Application for removal or variation of a condition following grant of
planning permission. Town and Country Planning Act 1990.
Planning (Listed Buildings and Conservation Areas) Act 1990

Number	<input type="text"/>
Suffix	<input type="text"/>
Property name	<input type="text" value="Shelley Lodge"/>
Address line 1	<input type="text" value="Layham Road"/>
Address line 2	<input type="text"/>
Address line 3	<input type="text"/>
Town/city	<input type="text" value="Shelley"/>
Postcode	<input type="text" value="IP7 5QX"/>

Planning Permission: DC/20/04576
Listed Building Consent: DC/20/04577

Varying to condition Schedule to new to drawing numbers:
Proposed Plans 1944/PD/202G
Proposed Elevations 1944/PD/230G

Elevation 5 (West)

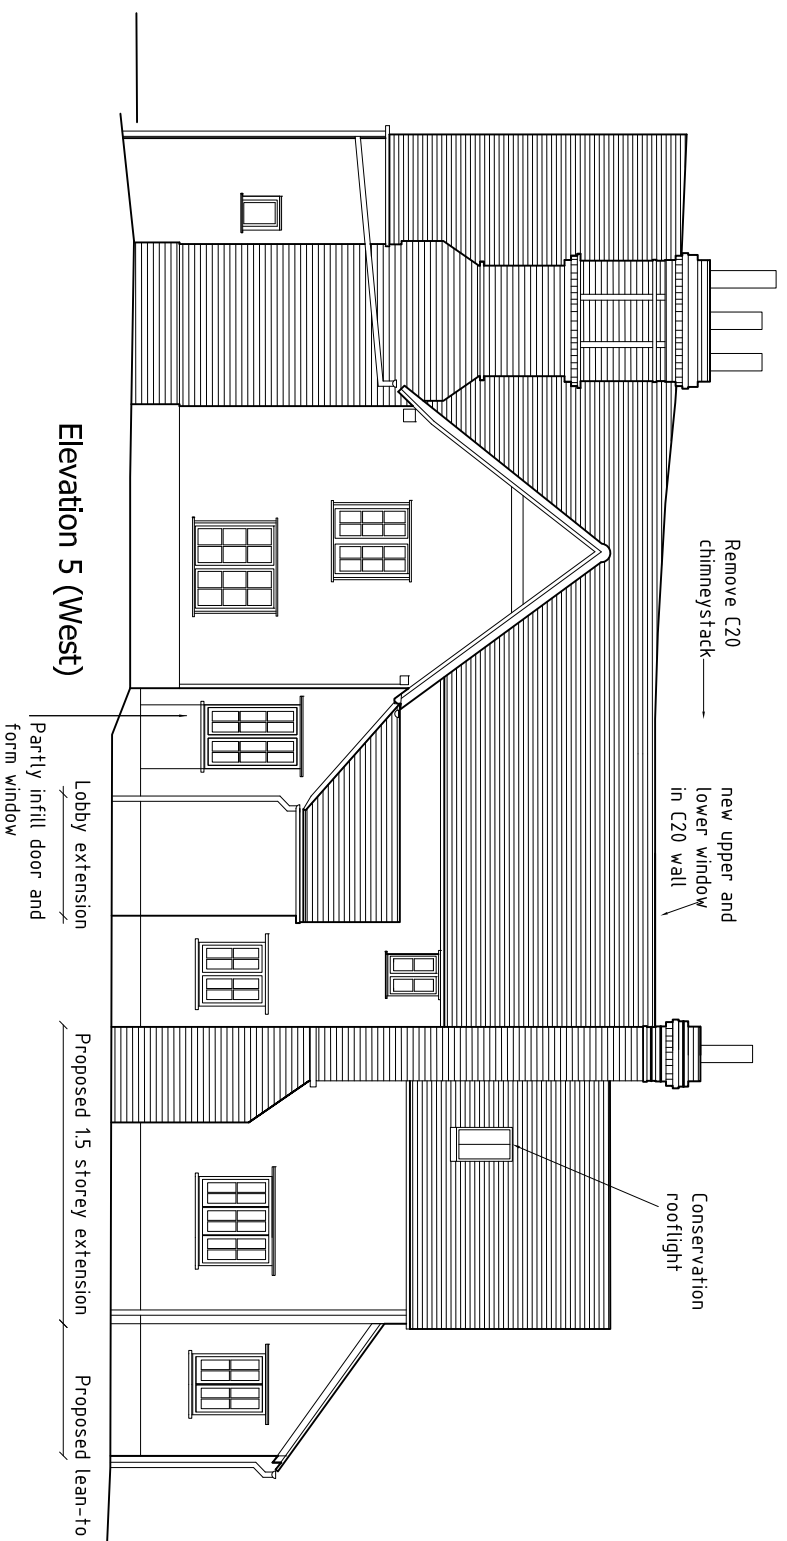
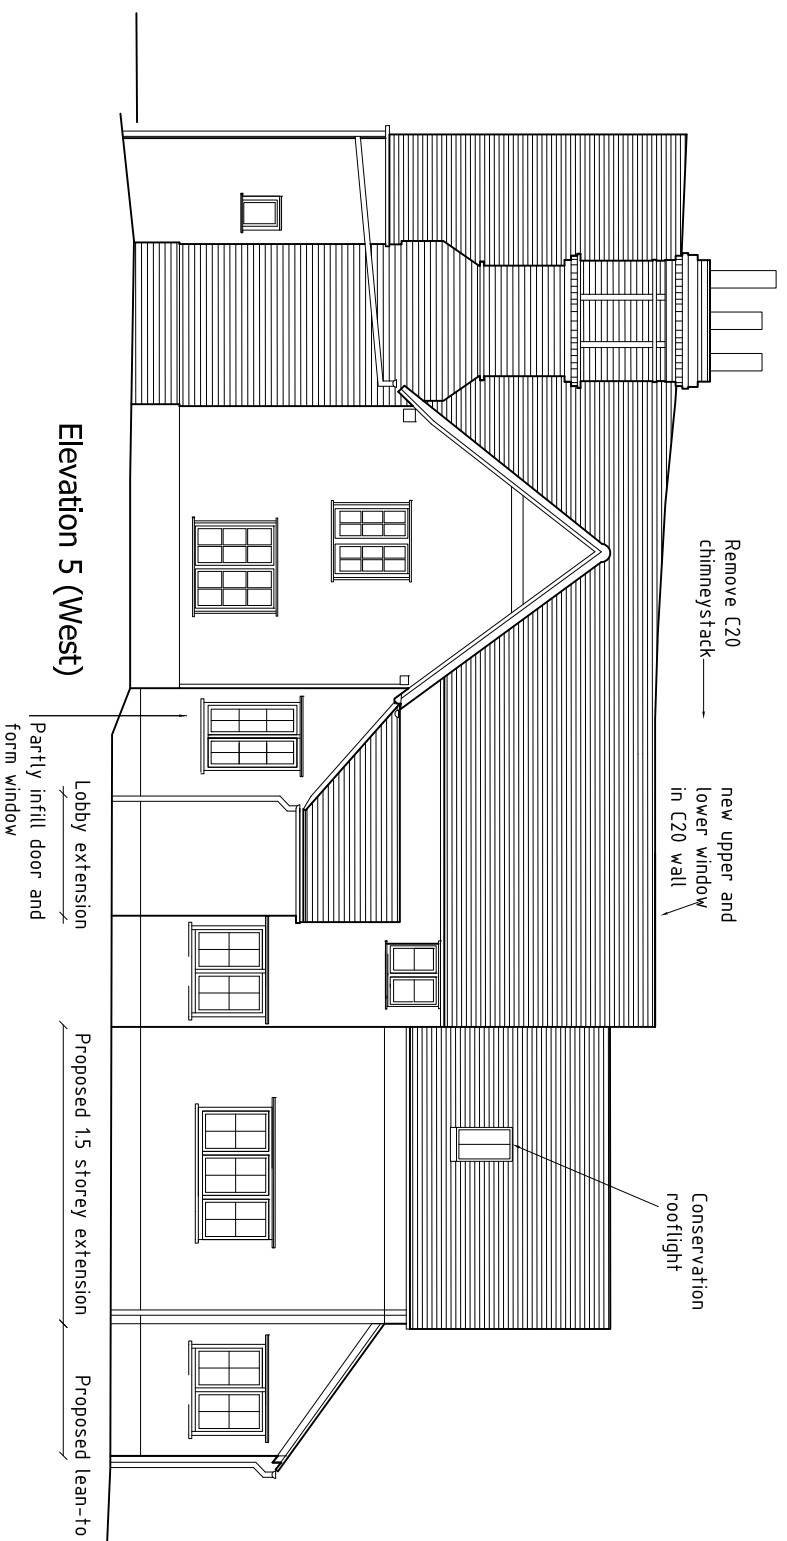
Variation - minor amendment to proposed extension - The new West Elevation chimney is to be omitted from the Approved extension (as the Aga will be Electric inline with the Governments directive to reduce oil fired boilers etc) and the approved windows on the new extension windows are all the same, albeit the one next to the chimney (omitted) now centralised and the windows are standard sizes.
